INDEPENDENT ADVISORY PANEL FOR UNDERGROUND MINING

**TAHMOOR SOUTH
LONGWALLS S1A – S6A
EXTRACTION PLAN**

August 2022

Tahmoor Extraction Plan
LWS1A to LWS7A
Plan 1 - Approved Plan

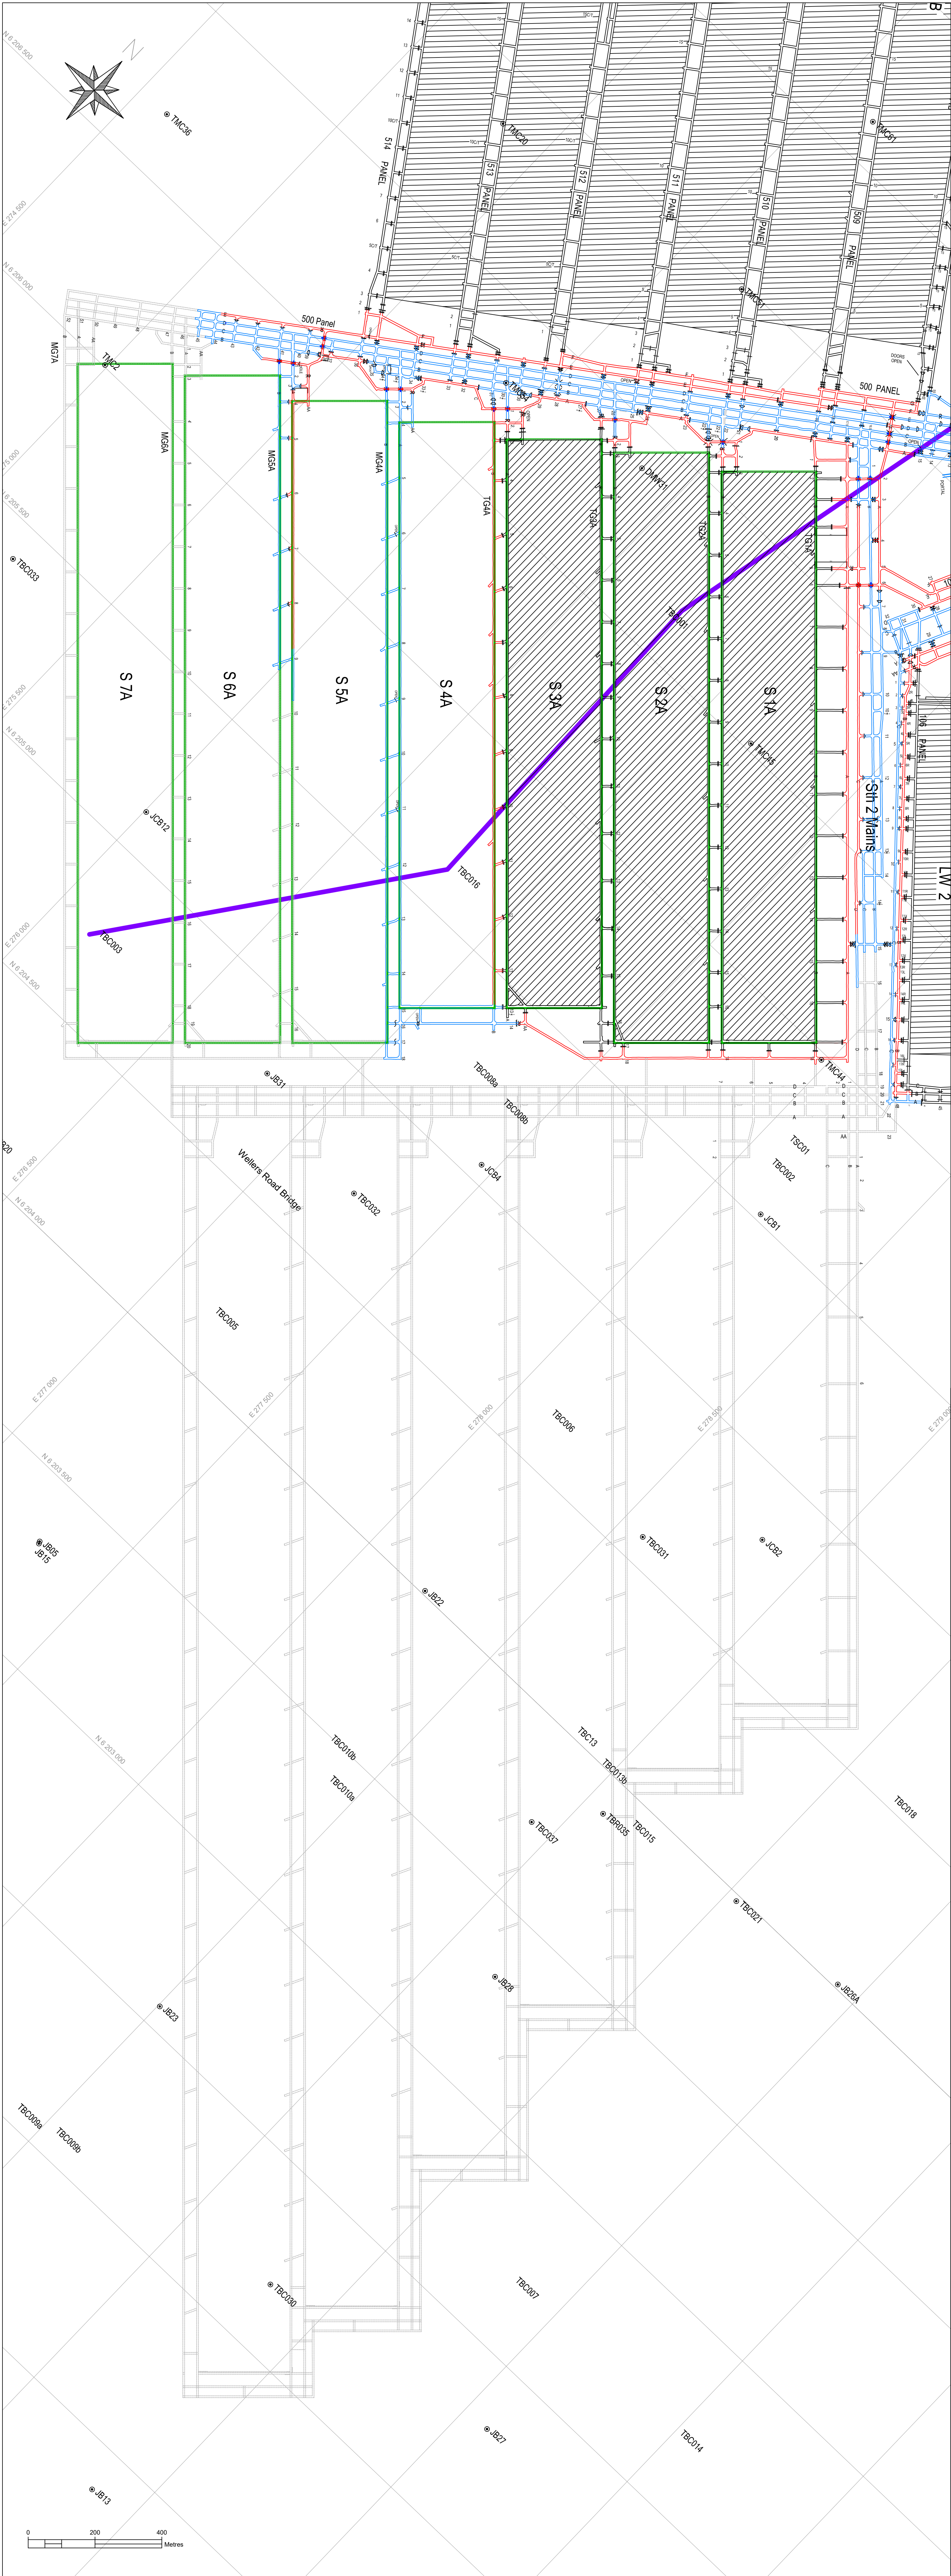
The location of this heritage site relative to the proposed mine plan is shown in Figure 2. The site location is marked on the boundary between LWS1A and S2A, marked as site 52-2-4471.

Given the location of this shelter above the panel edge of LWS2A, it will clearly be subject to subsidence effects including vertical subsidence, tilt and tensile strain – all of which have the potential to induce adverse impacts such as those noted above. Such impacts would then result in potential damage and/or loss of the rock shelter. Under the Development Consent conditions, this would then account for the 10% limit of impact to the total of 19 rock shelters, meaning that no further rock shelter impact would be permitted across the subsequent longwall B panels further to the south. The nature, quality and locations of the other 18 rock shelters is not known by the Panel.

Given this situation, whilst it would be technically permitted under the Development Consent to allow adverse impacts to occur at this first site, it is the Panel's view that it may be prudent to consider implementing some mitigation measures prior to the approach of both LWS1A and S2A, to minimise the likelihood of serious impacts occurring. This should be done in conjunction with an assessment of the relative merits, value and mining impact susceptibility of all of the 19 rock shelters, in order to prioritise which 18 of these 19 (as a minimum) need to be protected.

It is recommended that subsidence impact mitigation measures be considered, and a mitigation plan developed for implementation in conjunction with the rock shelter above the boundary between LWS1A and LWS2A in order to minimise the risk of adverse impacts to this rock shelter.

The above recommended mitigation plan should be developed in conjunction with and informed by a broader assessment of the relative merits and value of all of the 19 rock shelters, in order to prioritise which 18 of these 19 (as a minimum) need to be protected.
